**CITY OF ALBUQUERQUE
PLANNING DEPARTMENT
August 6, 2014
DRB Comments**

PROJECT # 1010178

RE: Lots 4A1A - 4A3A, Horne Development Addition

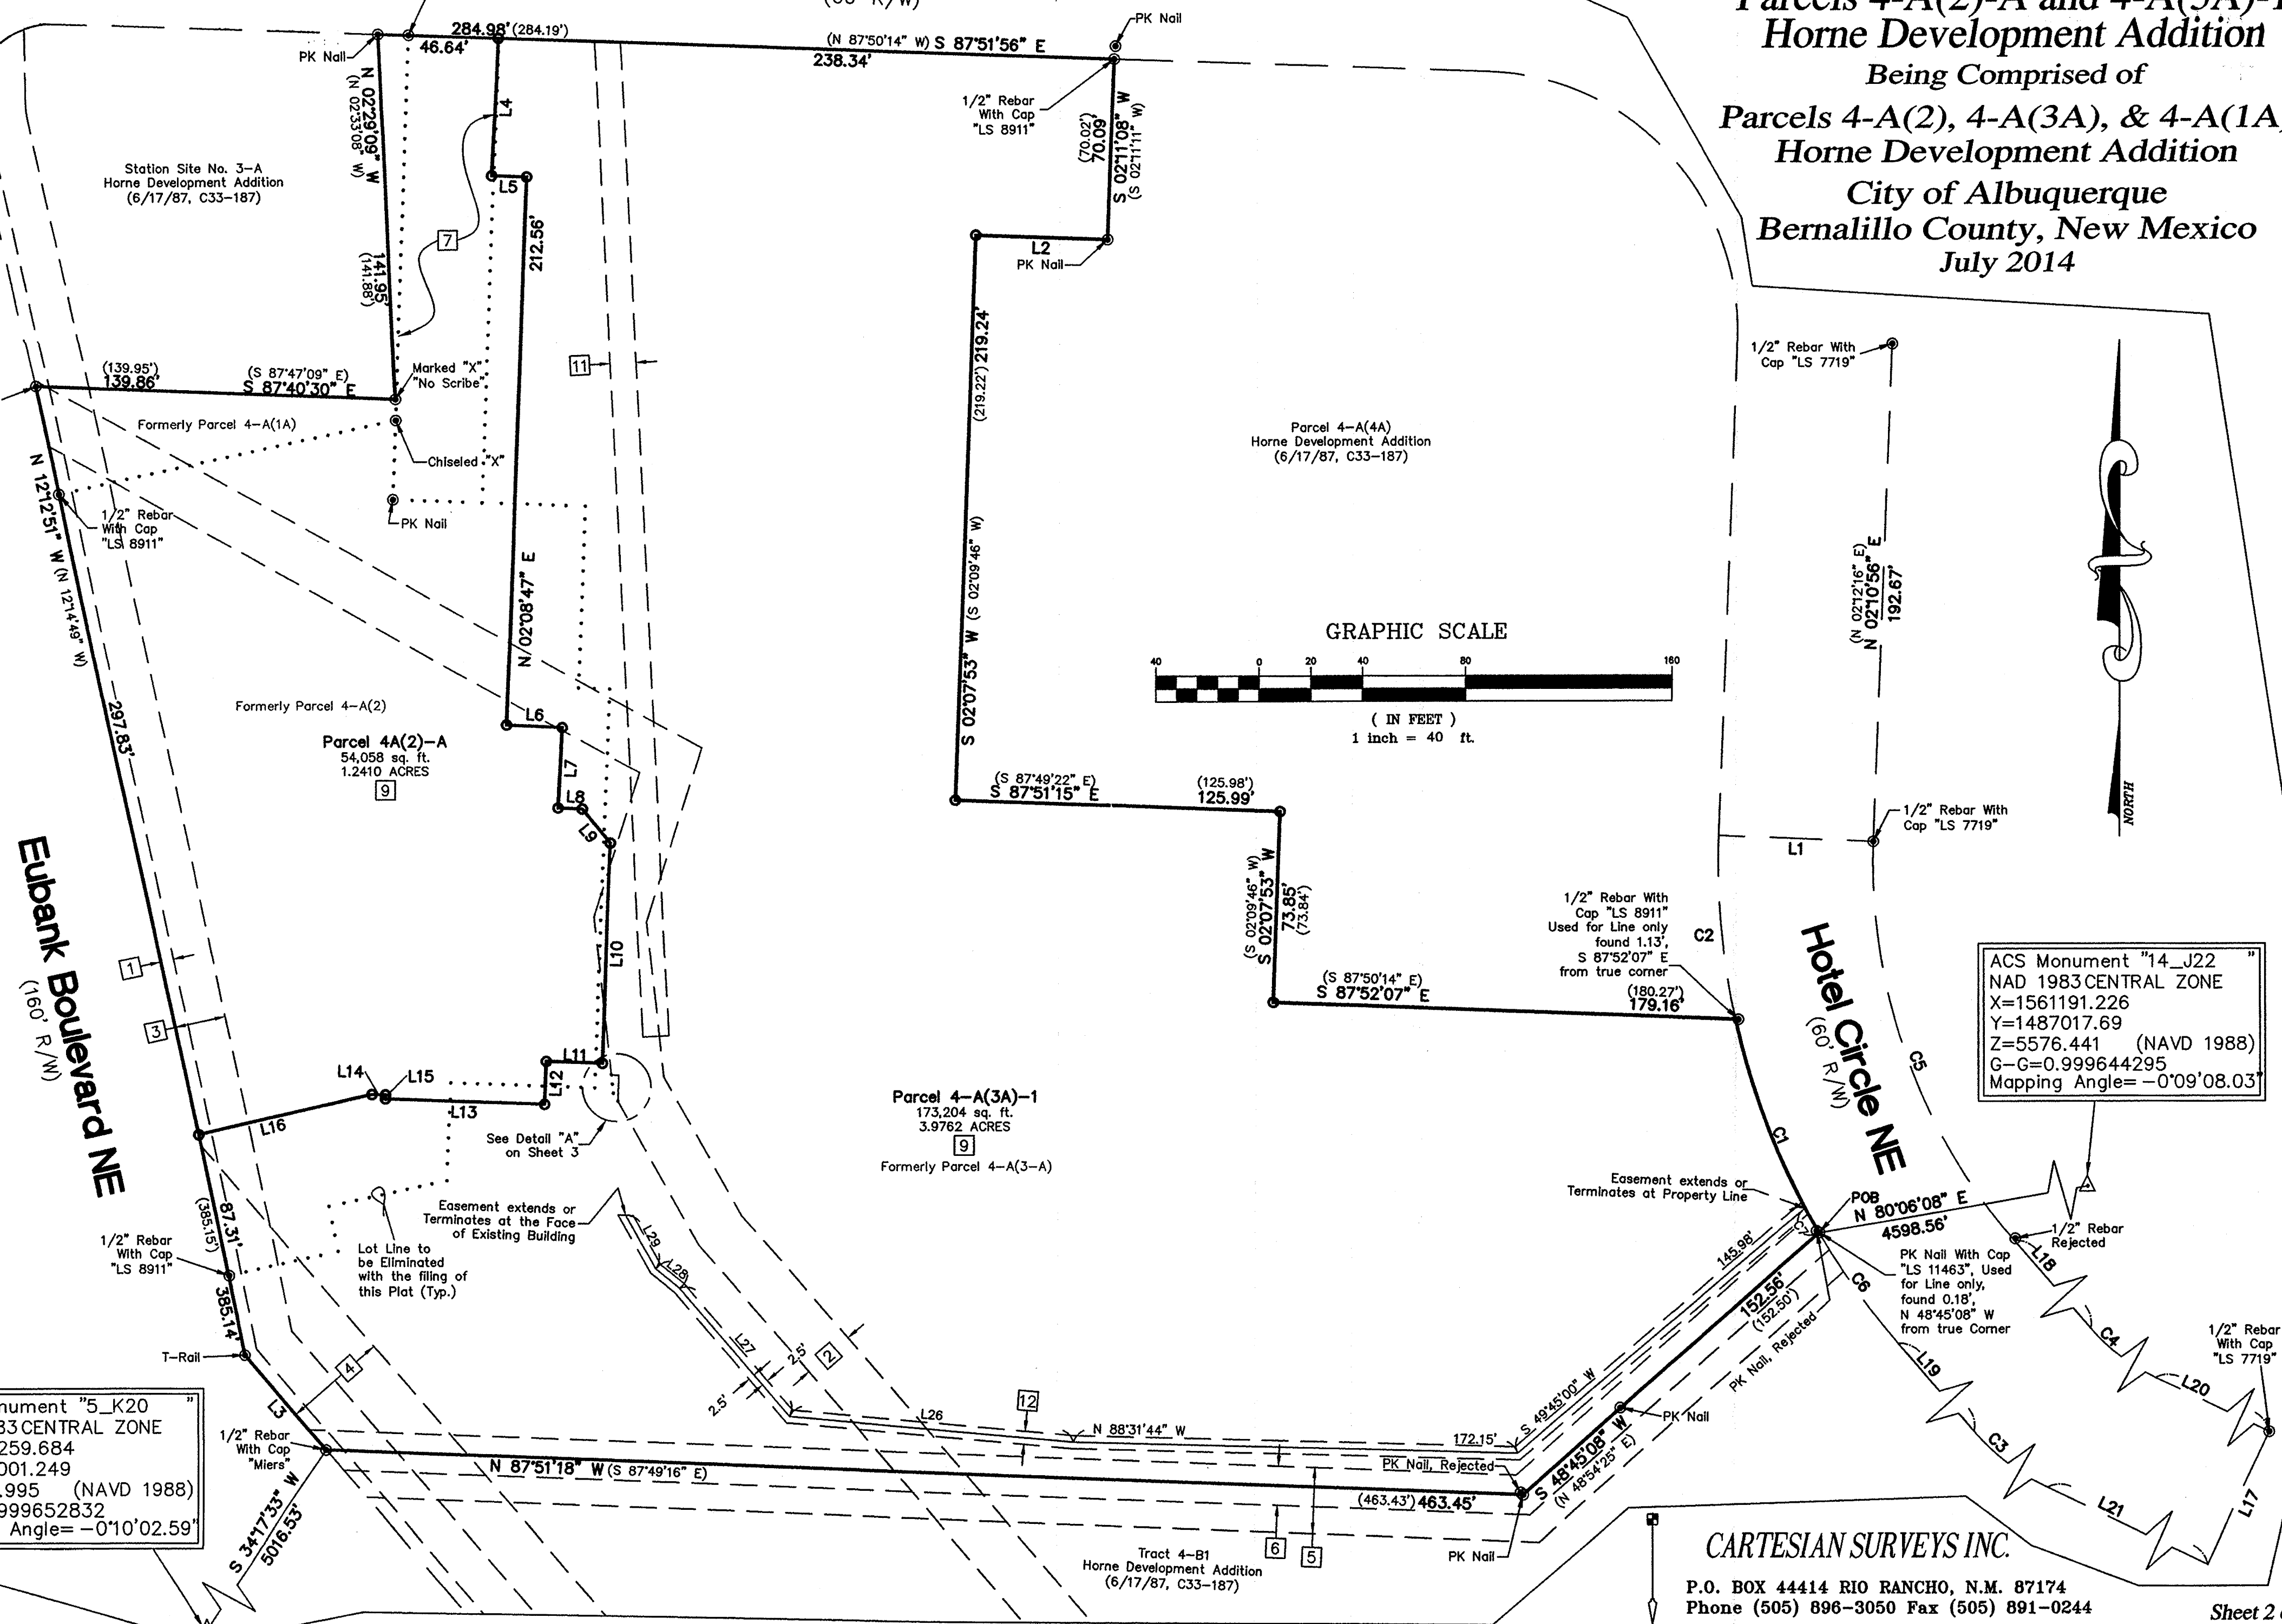
A Professional Engineer or Architect needs to certify that the common wall on the proposed lot line meets the current Building Code.

Reciprocal Access, Drainage and Parking Easements will be needed on the plat.

Having reviewed the existing conditions, I hereby certify that the walls wherein the proposed lots line adjustments are to be located meet the provisions of a "Fire Wall" as described in the International Building Code.

There are two conditions where the current "Conference Center" building abuts the existing Sadies restaurant building. In each case, two distinct walls were constructed. There appears to be complete structural separation between the structures, essentially creating separate buildings and suggesting that the "structural stability" requirements of a Fire Wall as described in IBC-2009, 706.2 have been met.

The restaurant building was constructed much earlier than the conference center building. The exterior walls of the restaurant are tilt up concrete panel and appear to be not less than 4" in thickness. The building code has ascribed a 3" wall to be equivalent to a one hour rating. There are two types of adjoining walls. The wall to the east is a 6" CMU wall. The code has ascribed this wall to be equivalent to a four hour rating. The southern wall abutting the restaurant was constructed with metal studs and two layers of 5/8" type "x" gypsum board on each side of the wall. This construction has been assigned a two hour rating. According to table 706.4, a fire wall separating Group A occupancies would need to be a three hour rating. This requirement is met in the existing construction.

As the existing walls all meet the requirements for a Fire Wall, it is our recommendation that the existing fire rated egress door be preserved and that a "joint egress agreement" be provided whereby emergency egress of the restaurant occupants is assured in perpetuity. We have directed Cartesian Surveying to include such language on the Final Plat.
